OUT20/13433

DPI Agriculture Assessment – Dunedoo Solar Farm Proposal (SSD 8847) Warrumbungle Shire

Figure 2. Map of government-estimated BSAL in the Dunedoo district (NSW Planning & Infrastructure 2013).

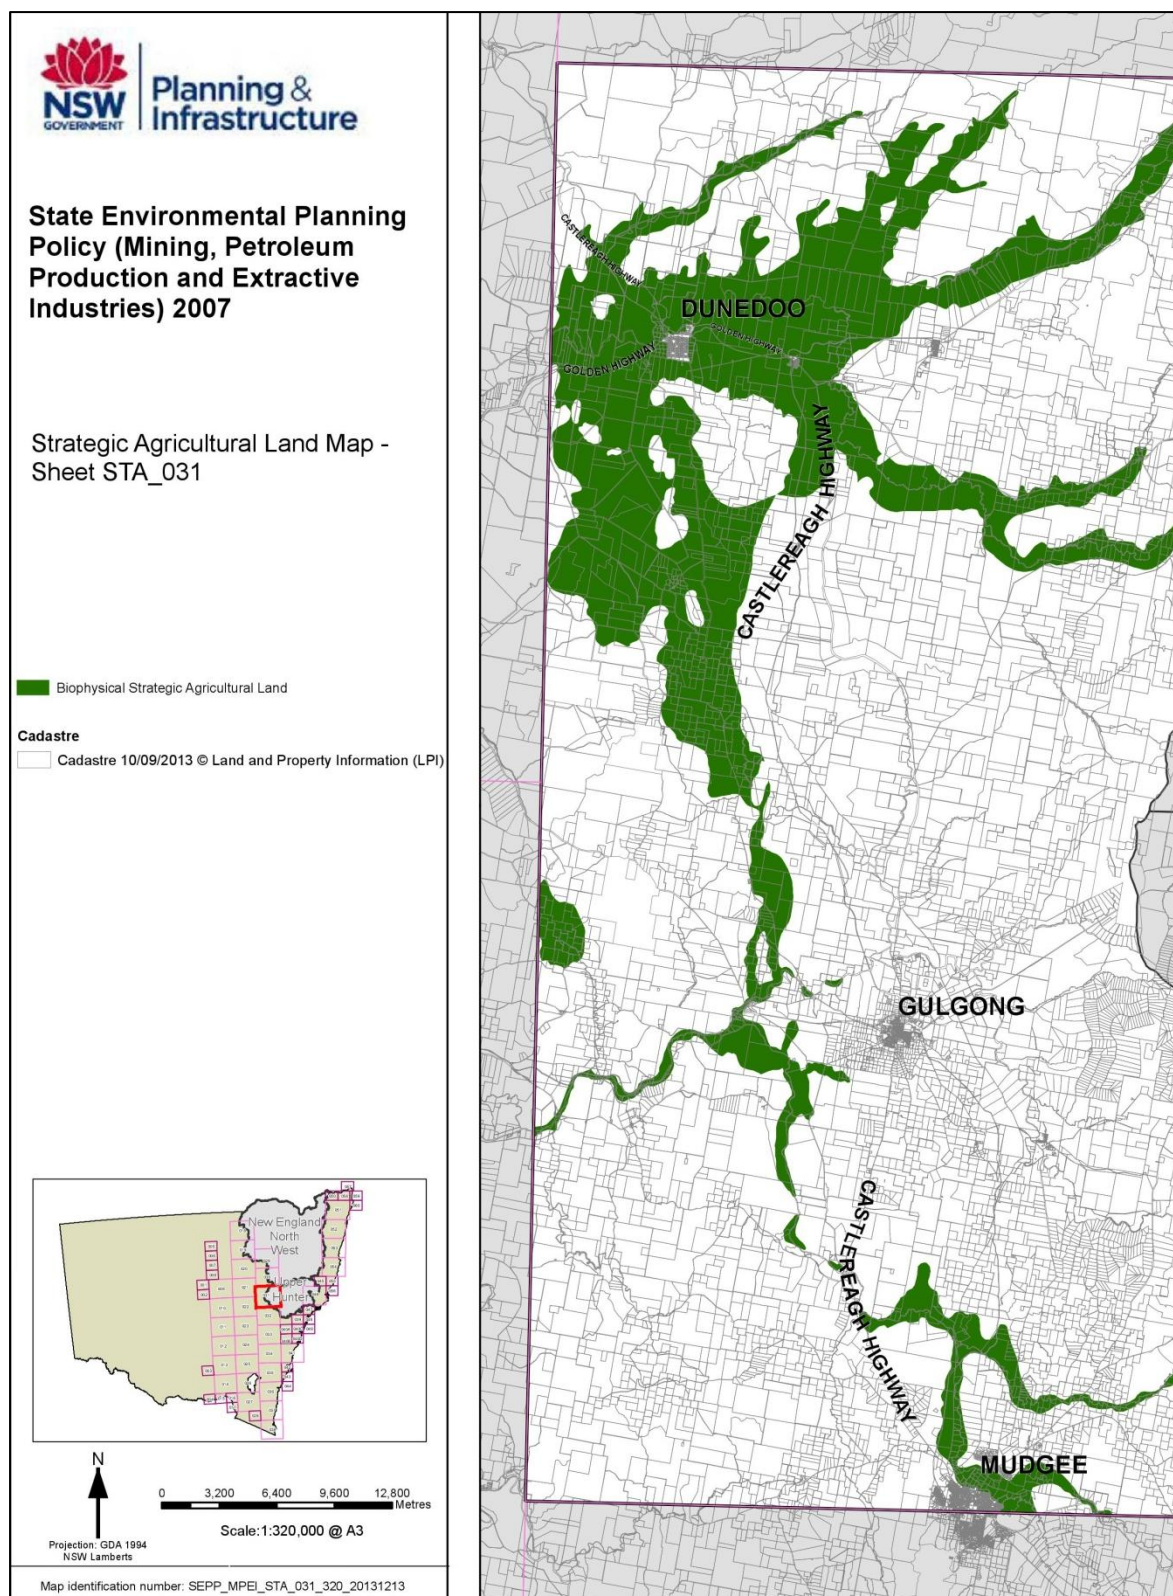
I note that 30% of the proposed development footprint is identified as Biophysical Strategic Agricultural Land (BSAL). BSAL is land with capacity to be highly productive and is limited to only 3.5% of the State. As per the Large Scale Solar Guidelines government's position is that solar developments should be located to avoid high quality agricultural land where possible. As such DPI requests information as to why the development footprint has not avoided that BSAL in this instance.
